**FP/135/25/PL**

The Fox Inn Waterloo Road Felpham PO22 7EH

*Change of use of first floor to provide 5 No. guest bedrooms with ensuites for short term stays, replacement timber pergola and replacement first floor windows*

FRONT ELEVATION
[east] 1:100

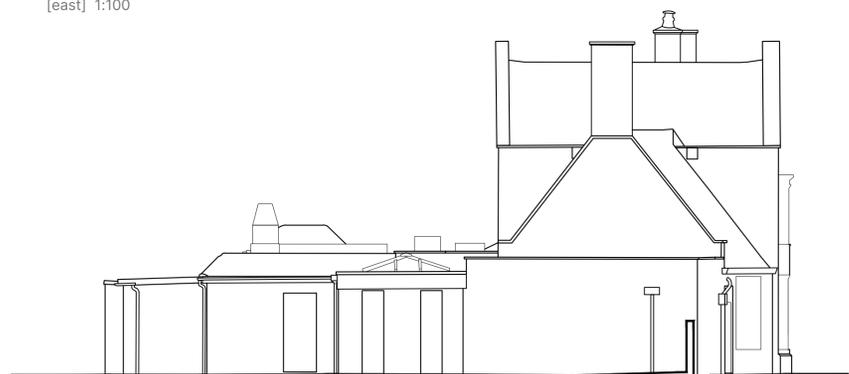
On the street-facing elevation, should replacement of the first-floor windows be necessary, the new glazing must replicate the existing pattern. For example, the top-hung quarterlights should incorporate a central vertical glazing bar, and the full-depth side-hung casements should be replaced in the same configuration to maintain the building's architectural integrity.

The bow window on the front elevation is a particularly fine and distinctive feature. Its curved fenestration complements the curve of the cornice, and any attempt to introduce straight sections of window framing would appear clumsy and inappropriate. Unless the replacement windows can precisely replicate the existing curved design, there is a strong case for retaining the original windows to preserve the character and appearance of the building.

The replacement pergola is located to the rear of the public house and would reflect one of a similar design already present. It is therefore acceptable.
